## TREE CONSULTATION RESPONSE

<b>Application No</b>	2025/0599
<b>Proposal</b>	Remove Ash tree T1 and Crack Willows T13 and T14, remove eastern stem and crown reduce remaining crown by 2-3m Goat Willow T4 and crown lift Cherry laurel T9 and G16 to 2.5m within TPO 5/2004.
<b>Address</b>	4 Mysten Croft, Barnsley, S75 1EP.
<b>Date of Consultation Reply</b>	25/11/2025
<b>Consultee</b>	Edward Jowett (Tree Officer)

Photo 4: Suggested reduction of T4 following removal of eastern stem

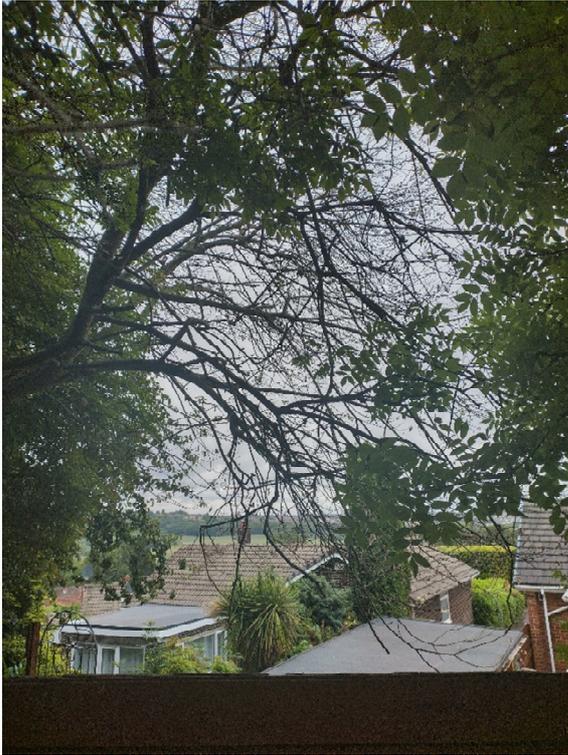
It is also proposed to prune Cherry Laurel T9 and mixed group G16 by crown lifting them to 2.5m to allow clearance and access under the canopies; there is no issue with the undertaking of this work as this is sensible maintenance. It is also proposed to remove the dead/dying eastern stem of Goat Willow T4 and then crown reduce the remaining two stems by 2-3m. The removal of the eastern stem is required and as such the reduction of the other two despite not generally being considered desirable is sensible in this instance given the loss of companion shelter through the removal of the stem. The reduction works will reduce the stresses from wind on the tree and give it the best chance to recover and adapt to the loss of the stem to be removed.

Tree Plan

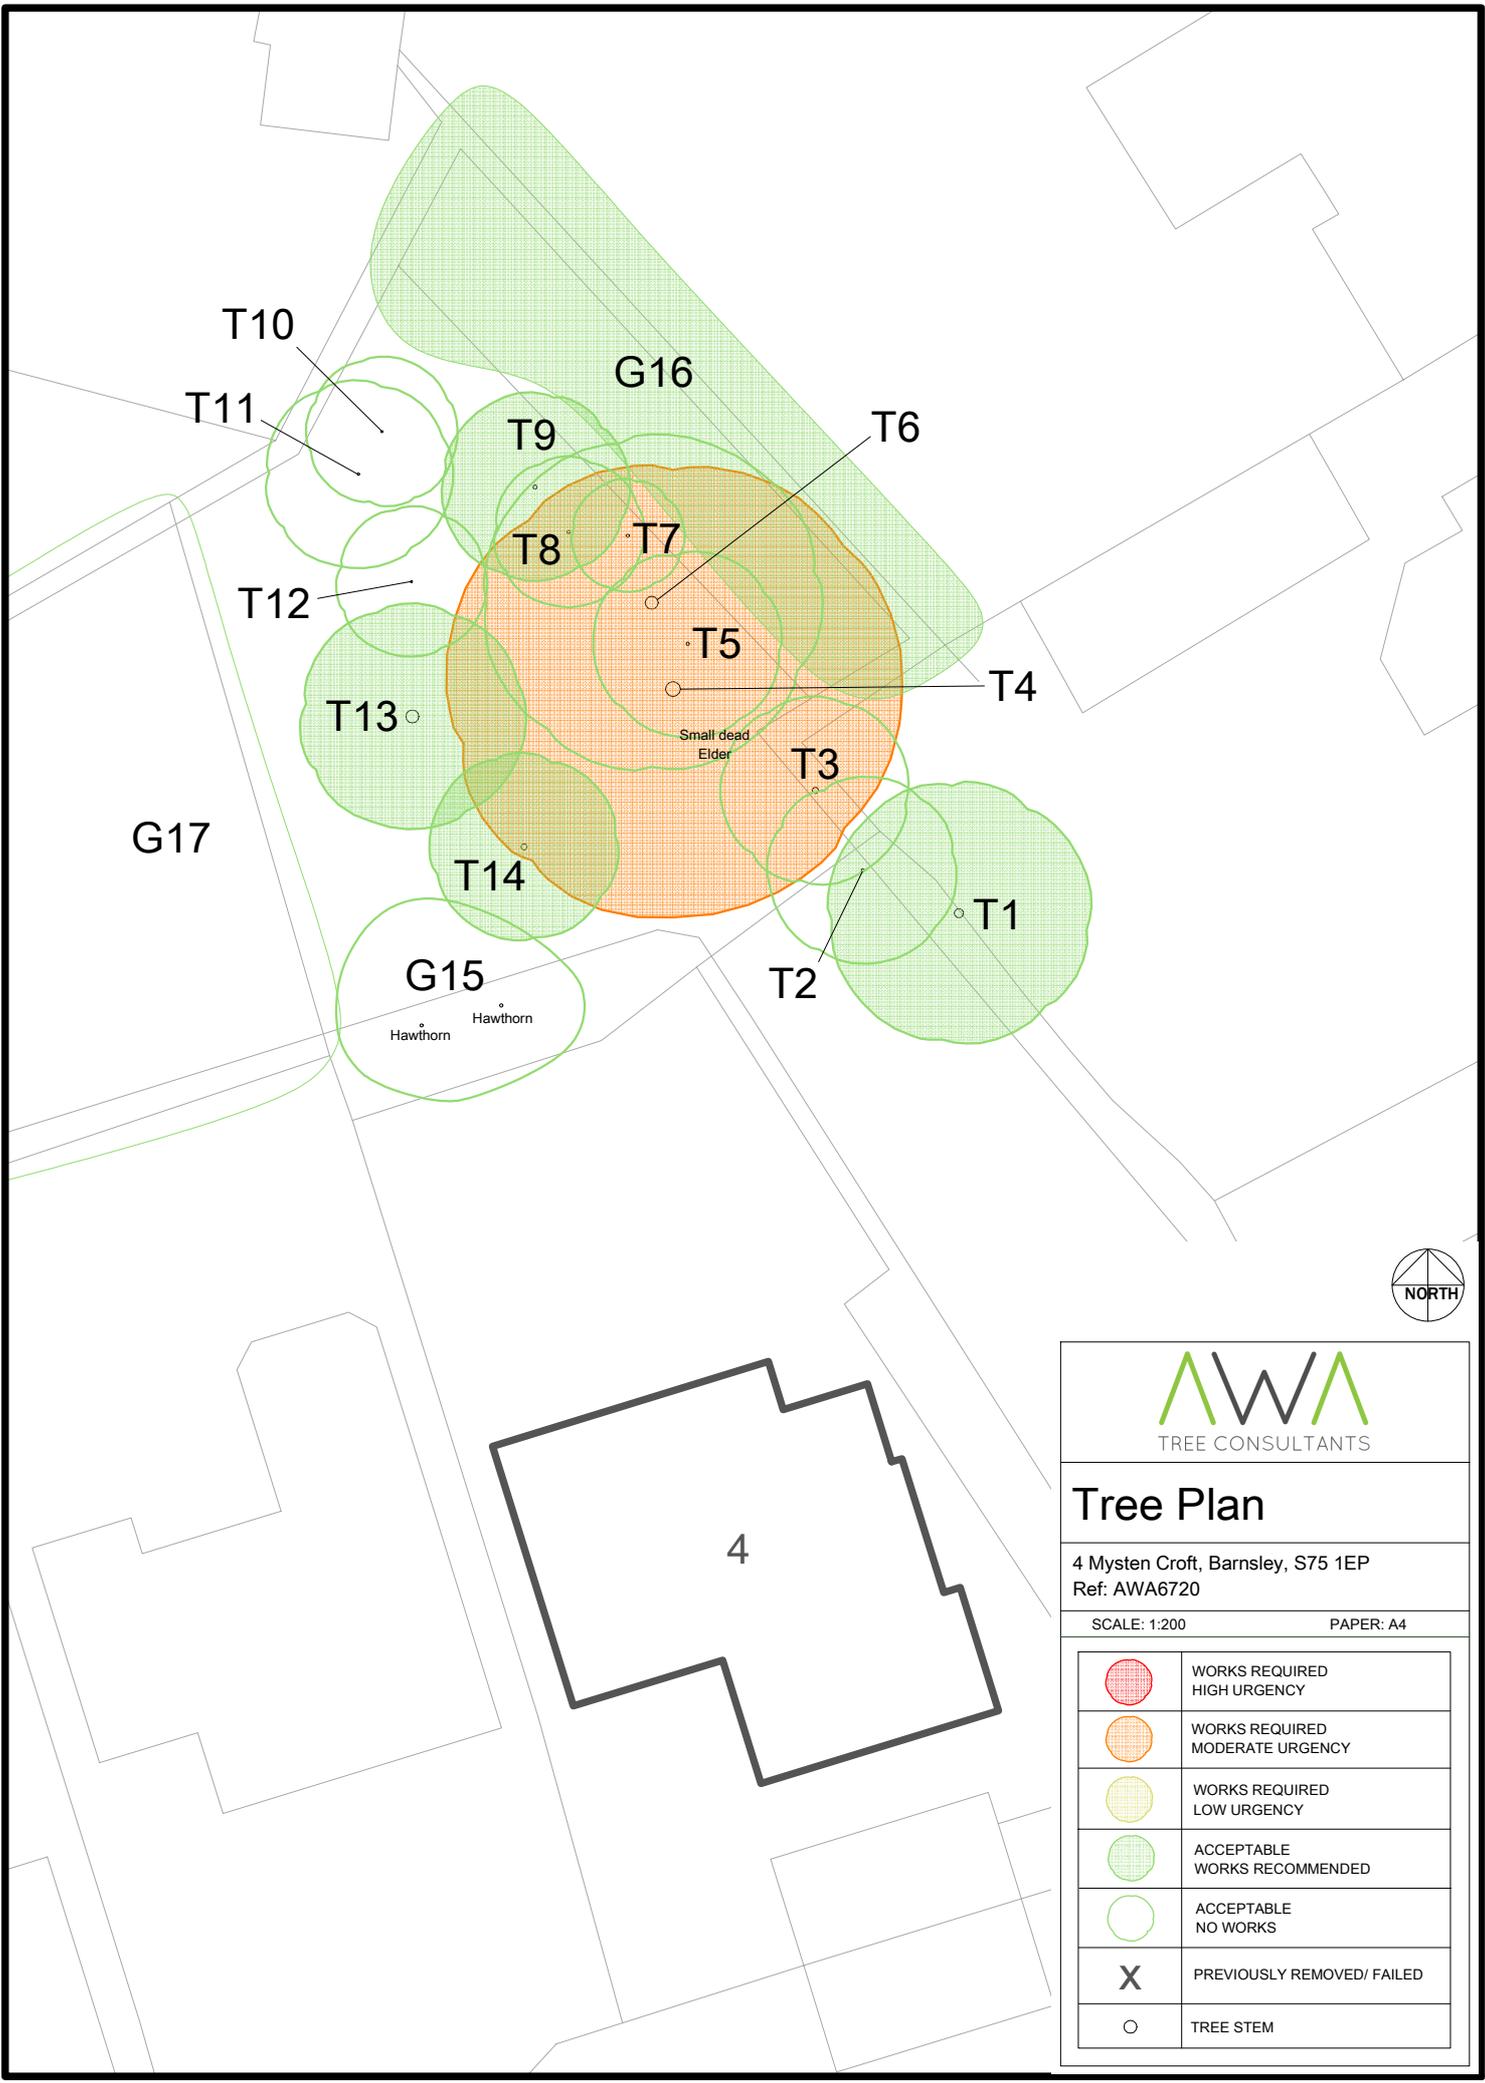
The trees to be removed are a young Ash tree and two dilapidated Crack Willows. The young Ash tree is a self-set specimen which is located on top of a retaining wall above a neighbouring property. It is evident from my inspection that there is ground movement in the area of the young Ash tree and it appears the land is beginning to slip, therefore there is no objection to the removal of this tree as the ground movement and level difference ultimately limit the trees retention span. The two Crack Willows are poor specimens which have been poorly managed in the past, ultimately the nature of their species make these unsuitable for this environment and when coupled with their generally poor condition removal and replacement is the sensible option. The three trees to be removed will need to be replaced, given the constraints of the site it seems sensible to replace with small to medium sized native trees and as such two new Silver Birch and a new Rowan have been specified.

Within the first planting season following the removal of the Ash tree and the two Crack Willows the trees to be removed shall be replaced by two new Silver Birch (*Betula pendula*) and a Rowan (*sorbus aucuparia*) to be planted one within 3m of each tree to be removed.
